STEWART BUILDING (L20-D57). GRADING AND DRAINING PLAN FOR RE: BUILDING AND SO #19 PERMIT APPROVALS. ENGINEER'S STAMP DATE JUNE 25, 1997.

RE: Drainage Plan for Stewart Building (L20-D57)

The review comments made by Carlos Montoya in his letter dated June 11, 1997 for the above referenced project have been addressed as follows:

RE: Drainage Plan for Stewart Building (L20-D57) Received May 27, 1997

STEWART BUILDING SITE GRADING AND DRAINAGE PLAN

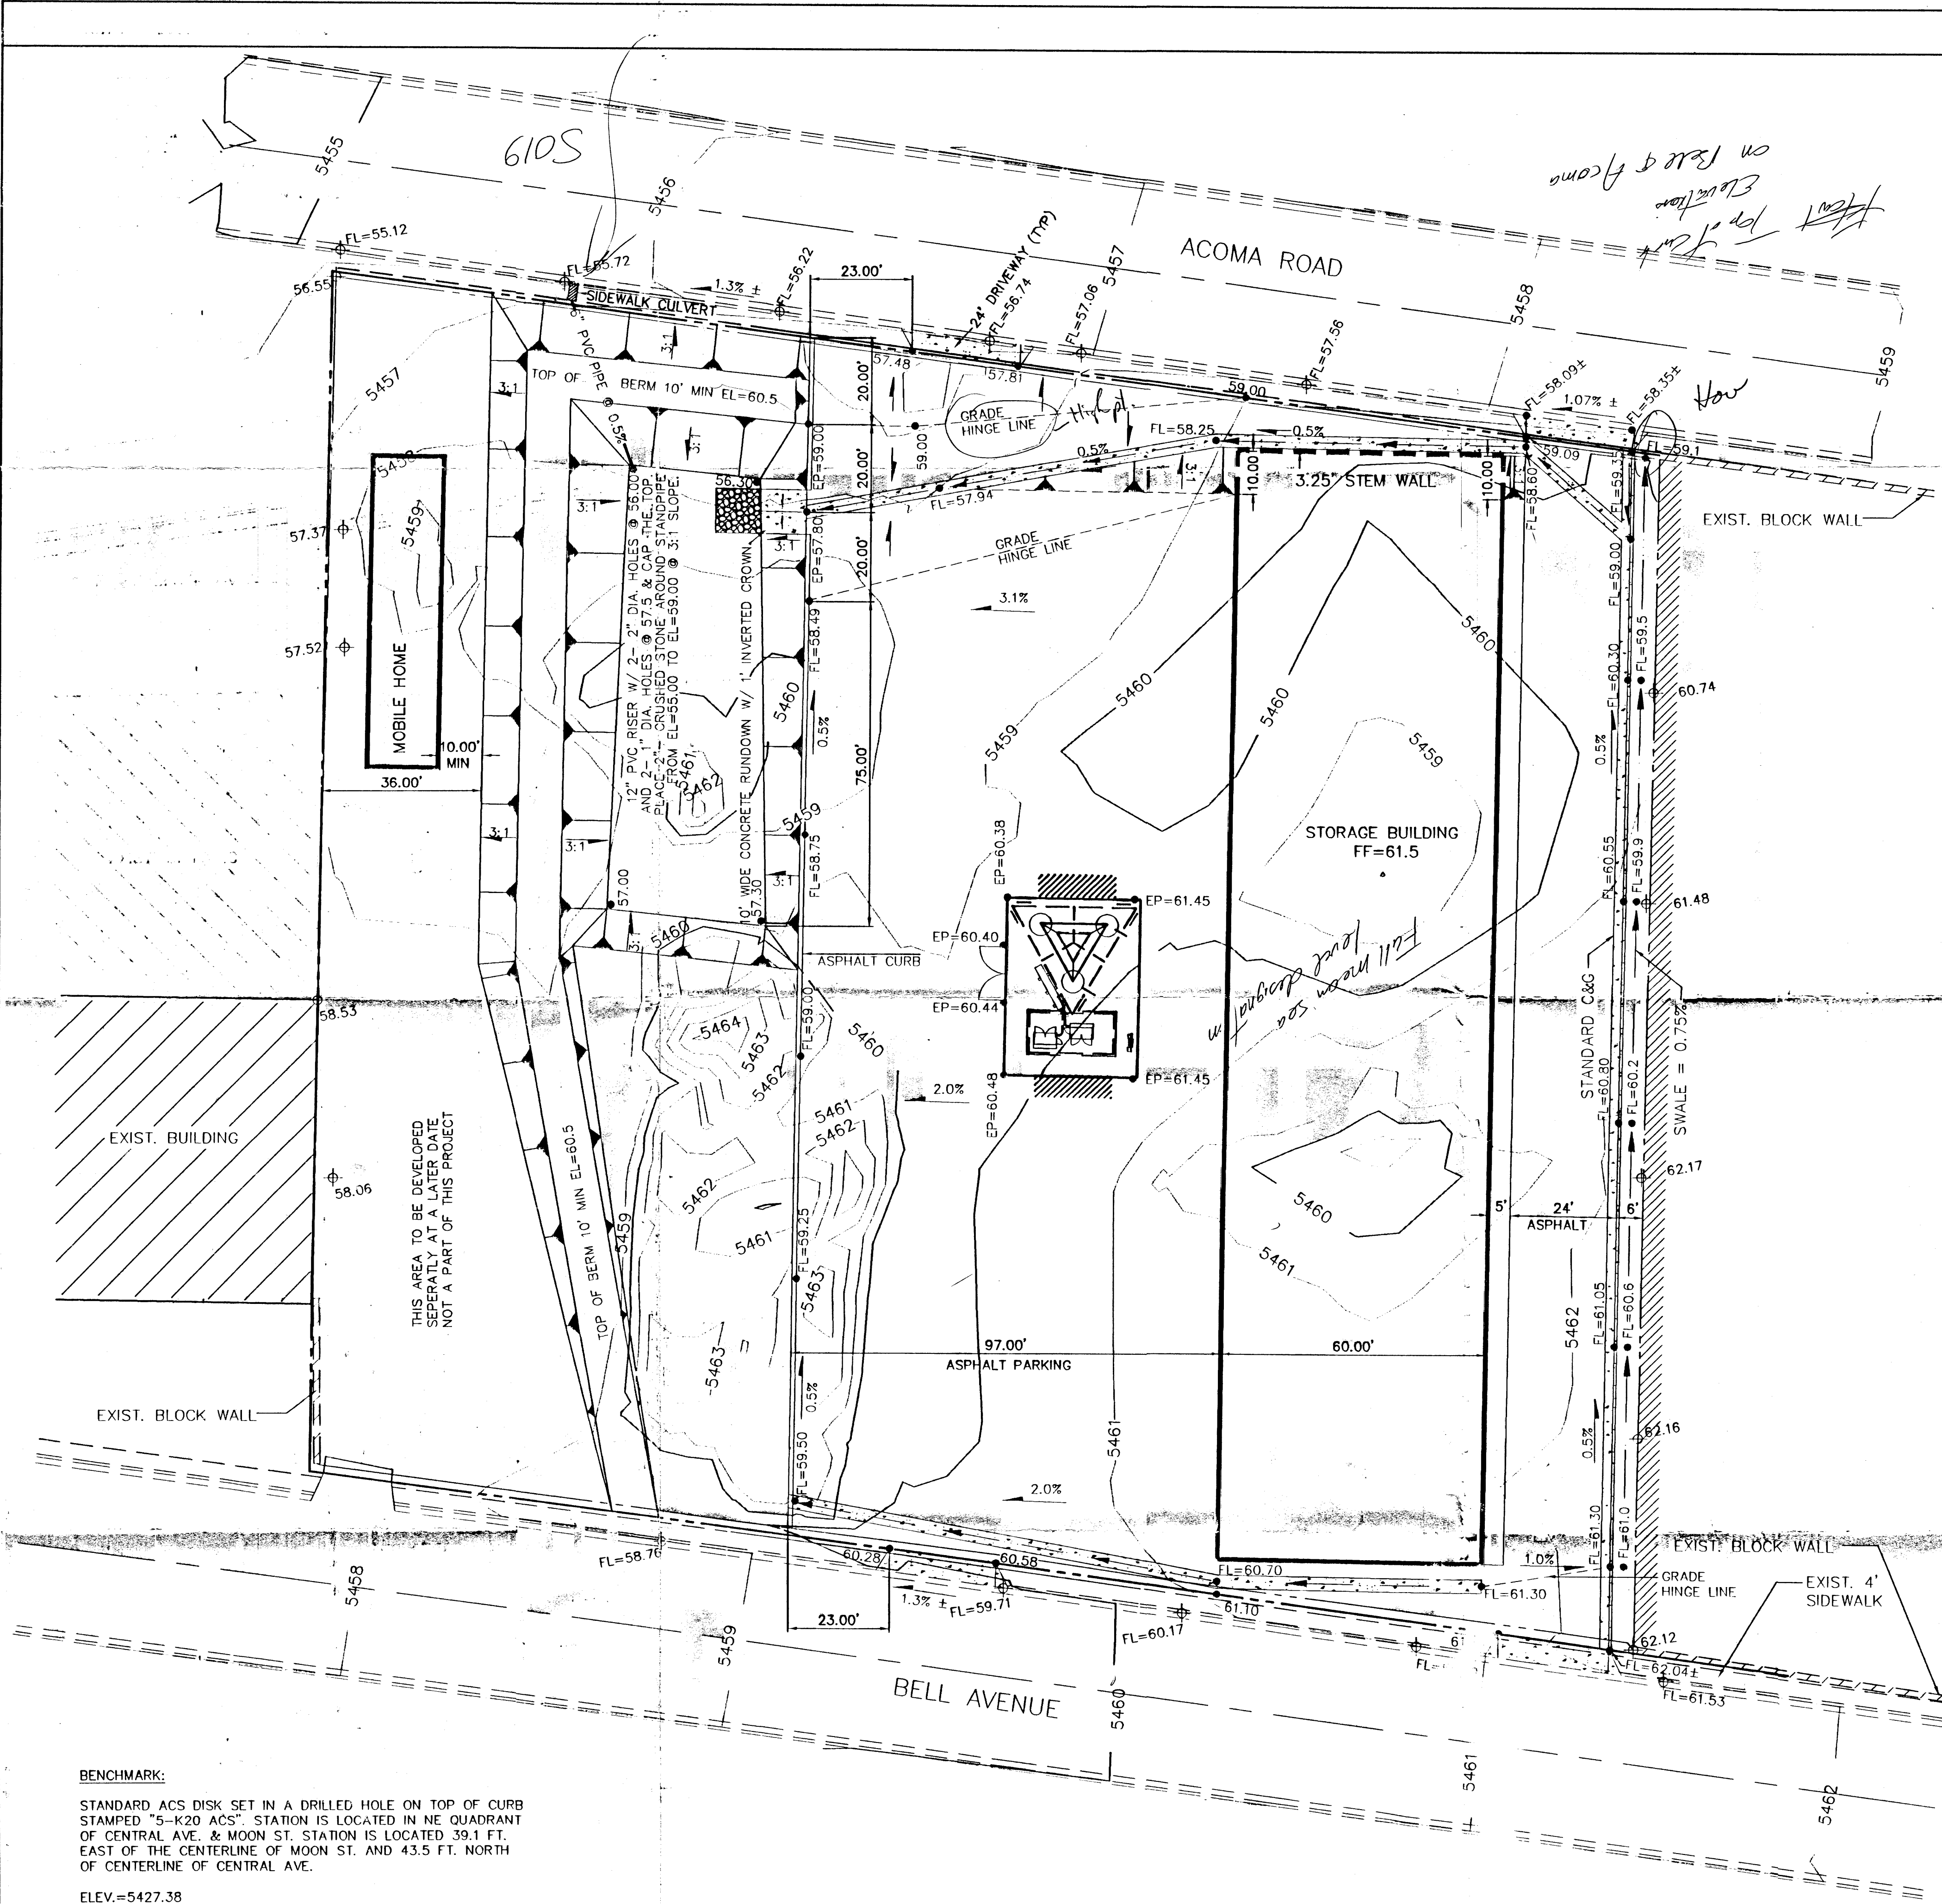
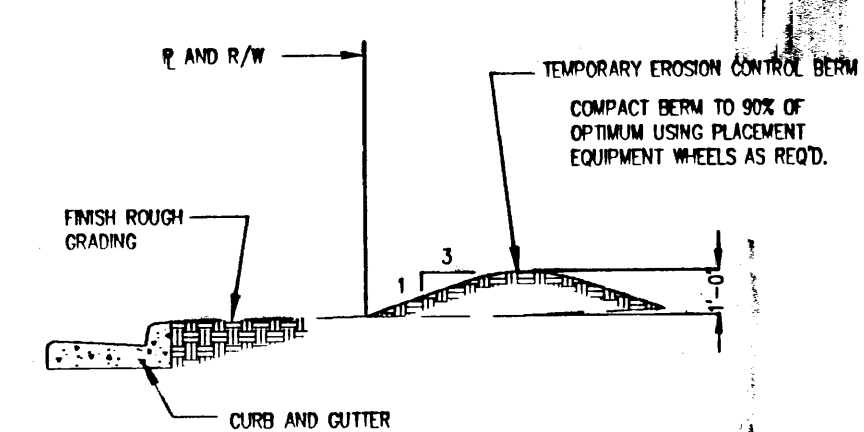
- 1. The construction of the sidewalk culvert in the City Right-of-Way will need to be processed through an SO #19.
- 2. Please submit the new plat with your next submittal. Otherwise, I need an agreement that allows cross lot drainage for the 10 lots.
- 3. When a property is developed you cannot discharge on to the downstream private property. If you do discharge on to the private property you need concurrence from the downstream owner.
- 4. Please give a detail of the proposed swales.
- 5. Please show the roof drains for the building and the mobile home.
- 6. Show proposed spot elevations for the proposed asphalt parking lot and 24 foot asphalt entrance.

7. If the pond depth is greater than 18 inches then the pond needs to be fenced.

- 1. The SO#19 for the sidewalk culvert will be processed at the time of construction.
- 2. A copy of the plat is attached. It has not been recorded at this time due to an issue between PNM and Mr. Stewart. As soon as this is resolved, Kym Dicome will sign the plat and it will be recorded. The attached FAX indicates Community Sciences Corporation latest attempts to bring this to closure. Please proceed with this drainage review assuming the plat will be recorded by the July deadline.

- 3. Per your request during our phone conversation on June 19, 1997, an erosion control berm has been added to the west property line of this site. This will prevent cross lot drainage until a permanent solution is incorporated with the next phase of development.

- 4. A typical detail for the swale has been added to the plans.
- 5. The direction of roof drain for the mobile home and storage building is not known. However, all of the flow from the storage building is conveyed to the pond via curb and gutter or valley gutters. Therefore, how the roof drains does not impact the drainage. Similarly, the mobile home drains to the northwest corner of the property as it does in its existing state. The erosion control berm which has been added to the plans ensures that the discharge point will be at the driveway. This meets the criteria we discussed on June 19, 1997.

- 6. The asphalt drains for the finished floor elevation of the storage building to the curb and valley gutters. Therefore, additional spot elevations are not needed. Existing flow line elevations have been added at the driveways. This provides elevations at the four corners.

- 7. A fence has been added around the pond.
